Our Ref: LU/2/19/PL

**Town & Country Planning Act 1990 (as amended)
Town and Country Planning (Development Management Procedure) (England) Order 2015
Application for Planning Permission**

Development Extension to existing warehouse with re-cladding of existing brick built unit to match (resubmission following LU/334/17/PL).

Location Unit 1 Lineside Way Littlehampton

Site & Location Plans

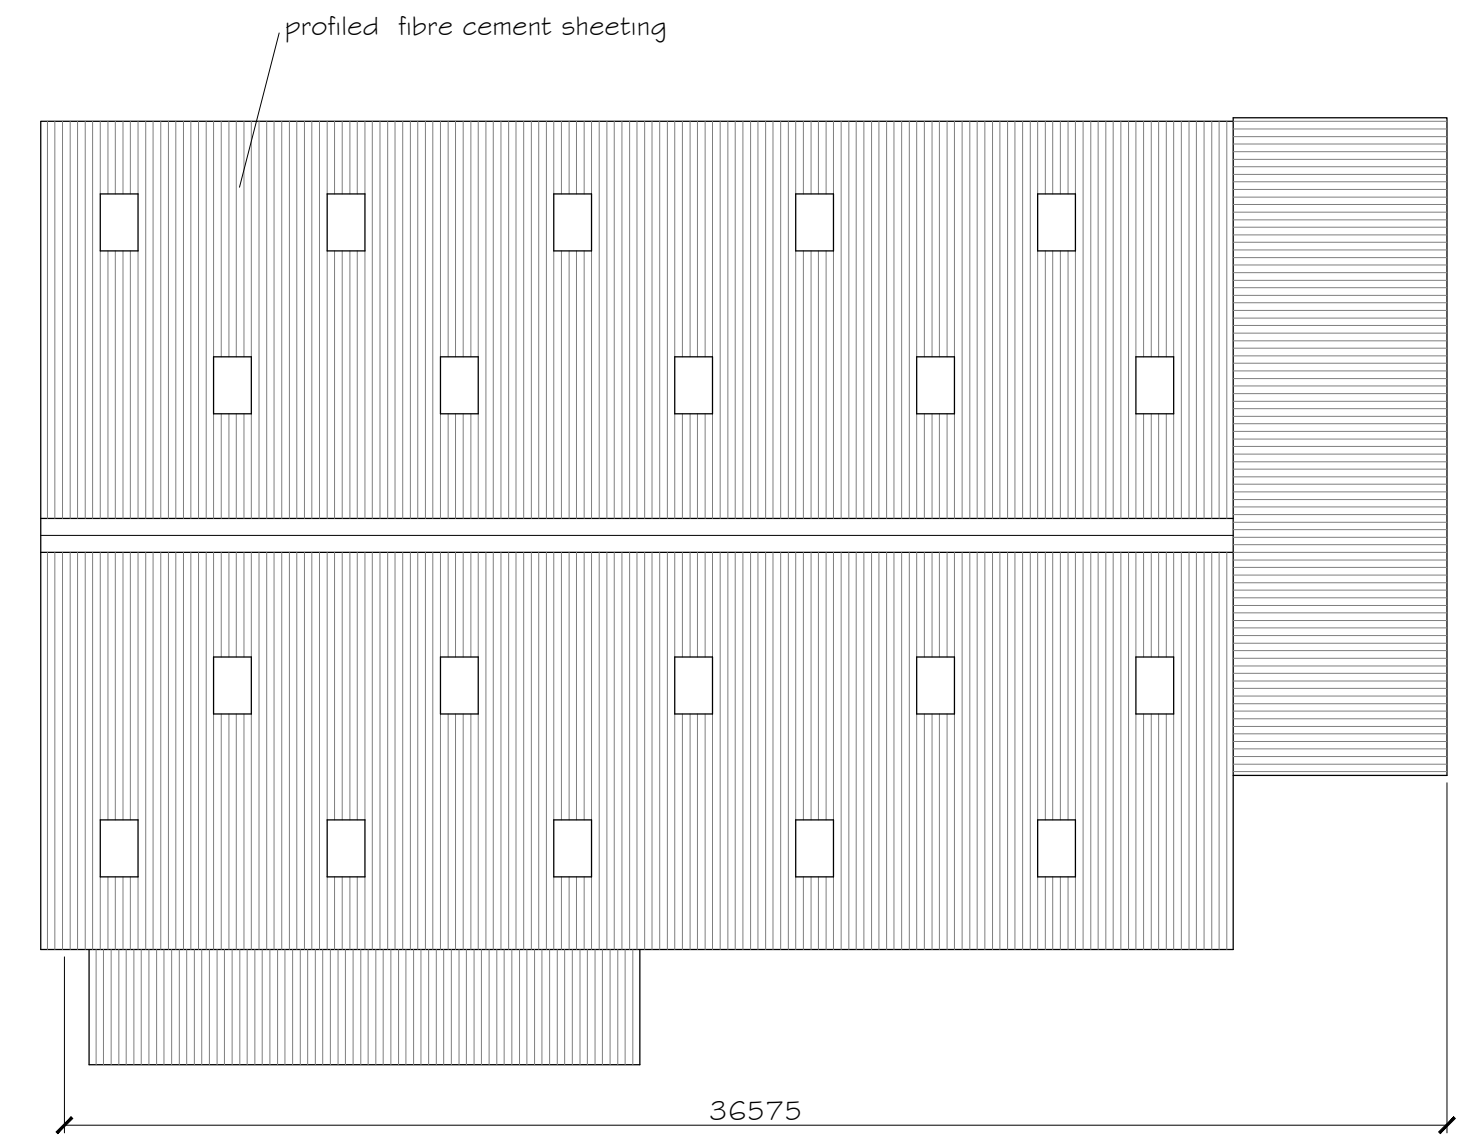
Block Plan

Please submit 1 electronic or 3 paper copies of a block/site plan at a scale of 1:500 or 1:200. Further details of what must be included on the plan can be found in the National Validation Requirements.

Rear (NW) Elevation
(Scale 1:200)

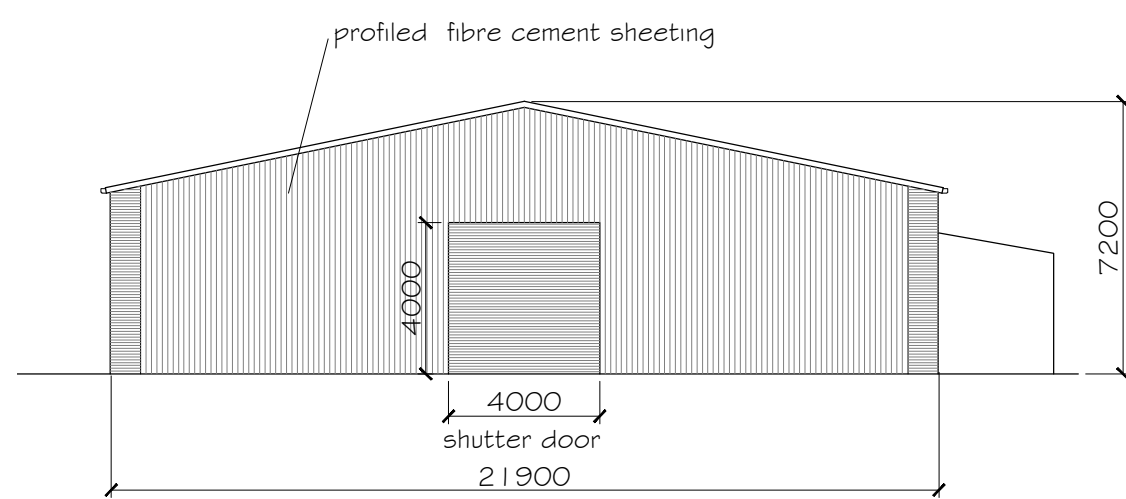
Please provide an existing rear elevation.
